**Consultation Response from Mike Hibbert,
 KC Waste Strategy(Refuse & Recycling)**

2024/92727 Land adjacent to, Ashbourne Drive, Liversedge

Erection of residential development 67 dwellings with associated access, parking, public open space, landscaping and infrastructure

Responding Ref: WPN 24-041

Drawing No. Z168.002 Rev. E

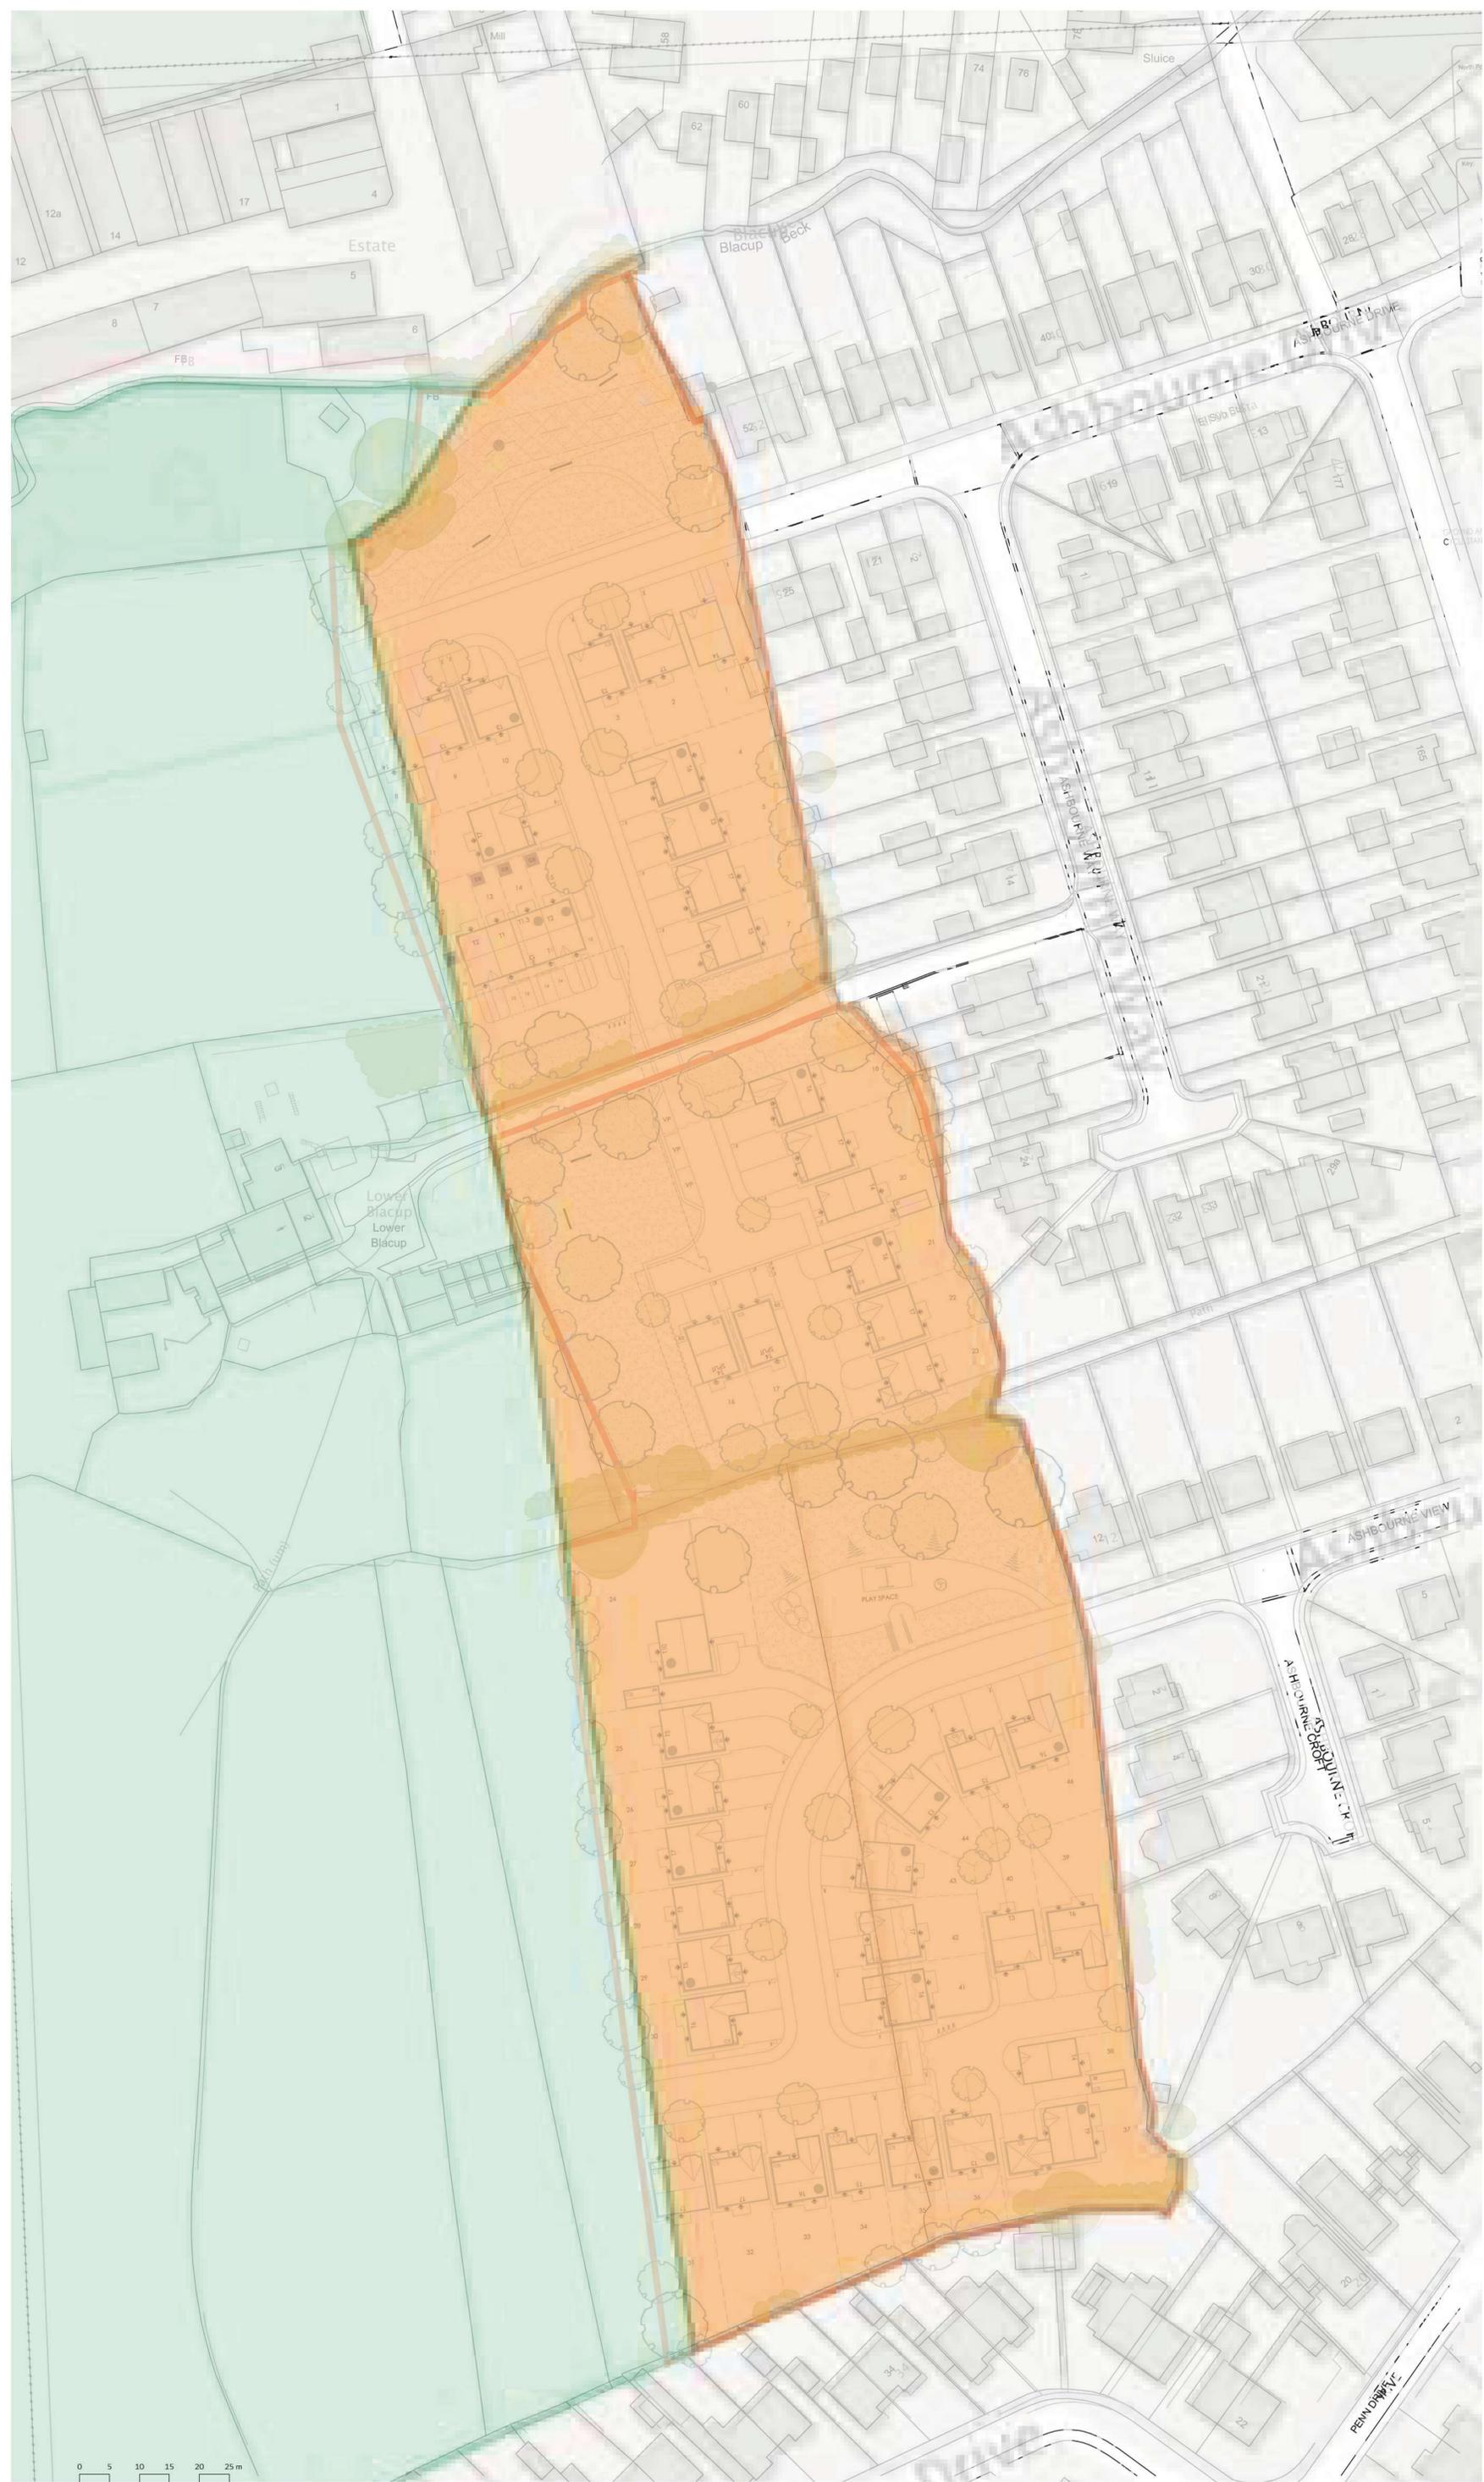
The proposal is for a mix of 67 dwellings. The applicant has submitted Drawing Title Planning Layout Drawing No. Z168.002 Rev. E dated 16/09/2024 that is annotated to show the location of bin stores and Bin Collection Points (BCP's).

- It is welcomed that the plan shows the storage for 3 x 240ltr bins at each property, 1x240ltr Residual, 1x240ltr Recycling and as the properties have gardens the space to accommodate a third bin for garden waste or to accommodate future changes to waste collection due to the implementation of Simpler Recycling legislation. As the proposed dwellings have private gardens, opportunities to encourage composting should be sought to better meet the council's 'clean and green' objectives for waste reduction.

- It is recognised that due to topography of the site plots 45 to 57 (House types of Fewston, Scotton and Middleton) cannot store bins in the rear garden. Details are required about the design and specification of bin stores at the front of properties. Bins

should not be located under windows/ next to doors. Wheeliebins located at the front of properties will be set within the Streetscene and therefore should be screened and secured to prevent bin blight, the spread of waste into the street, unauthorised use and theft/damage to bins.

- There are no details about bin storage for the show house on Plot 67.
- It is welcomed that space for the presentation of bins on collection day is indicated on the plan for Plots 15-18, 45-47 and 55-59. It is important to ensure that bins do not cause obstruction to pedestrians or other highways users when presented for collection, particularly where space requires these to be left in clusters. Bin presentation space should be on a hard surface and where a refuse collection vehicle (RCV) can be easily reached.

- To facilitate loading of full wheeliebins the surface between the bin store/ BCP and the highway should be smooth hard surface without kerbs. The proposed layout must ensure that parked cars do not obstruct the route between the bin store and loading point.

- Parked cars are a perpetual problem for RCV access and as such it is important to account for potential parking spaces, even where these are undefined when assessing RCV access around the site. If turning heads are blocked by parked cars as maybe the case in the turning head between plots 23 -2 4 and 37 - 39 this would require a long reversing manoeuvre. **The Waste Industry Safety and Health (WISH) Forum guidance states “Reversing causes a disproportionately large number of moving vehicle accidents in the waste/recycling industry. Injuries to collection workers or members of the public by moving collection vehicles are invariably severe or fatal. BS 5906: 2005 recommends a maximum reversing distance of 12 m.”**
